National Grid Electricity Transmission – Sea Link – EN020026

Saxmundham Town Council

Comments on Applicant's Change Request

Benhall Bridge – Traffic Diversion Route

Sea Link

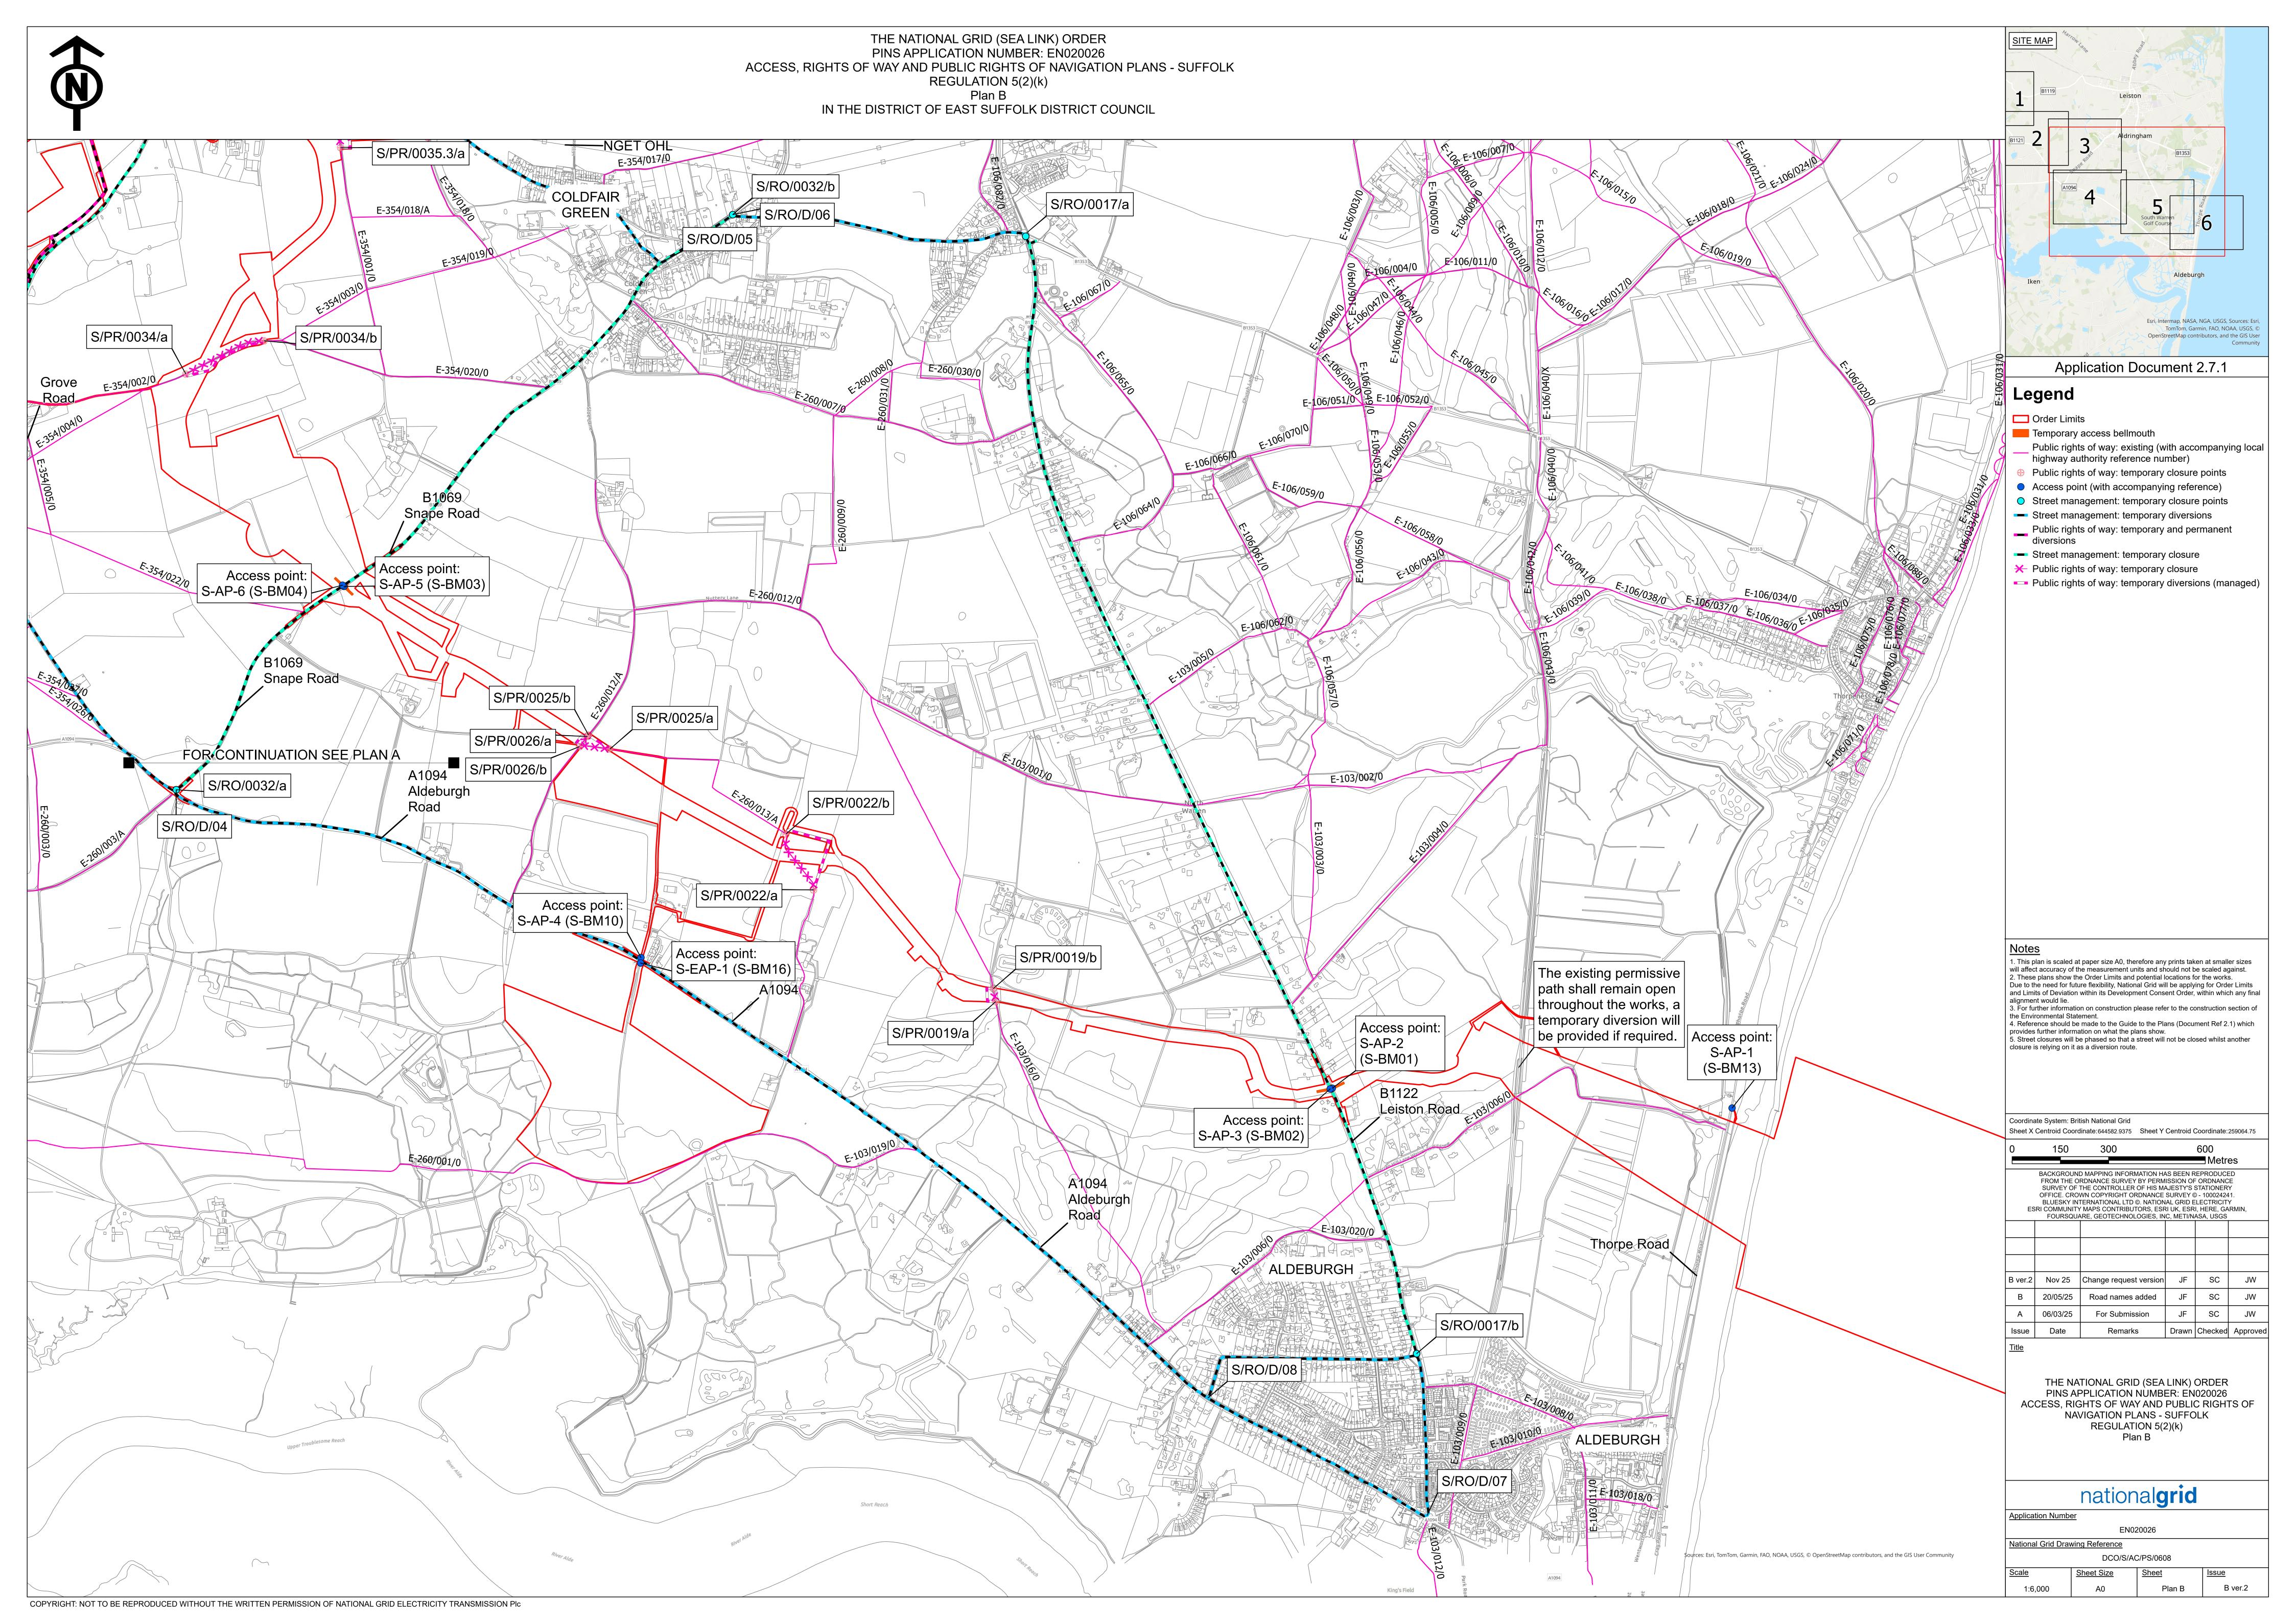
Ensuring HGVs do not follow the diversion route as illustrated on *Document 2.7: Access, Rights of Way and Public Rights of Navigation Plans, Version: B Version 2 Change Request, November 2025* but instead use the designated HGV routes identified by Suffolk County Council Highways.⁴
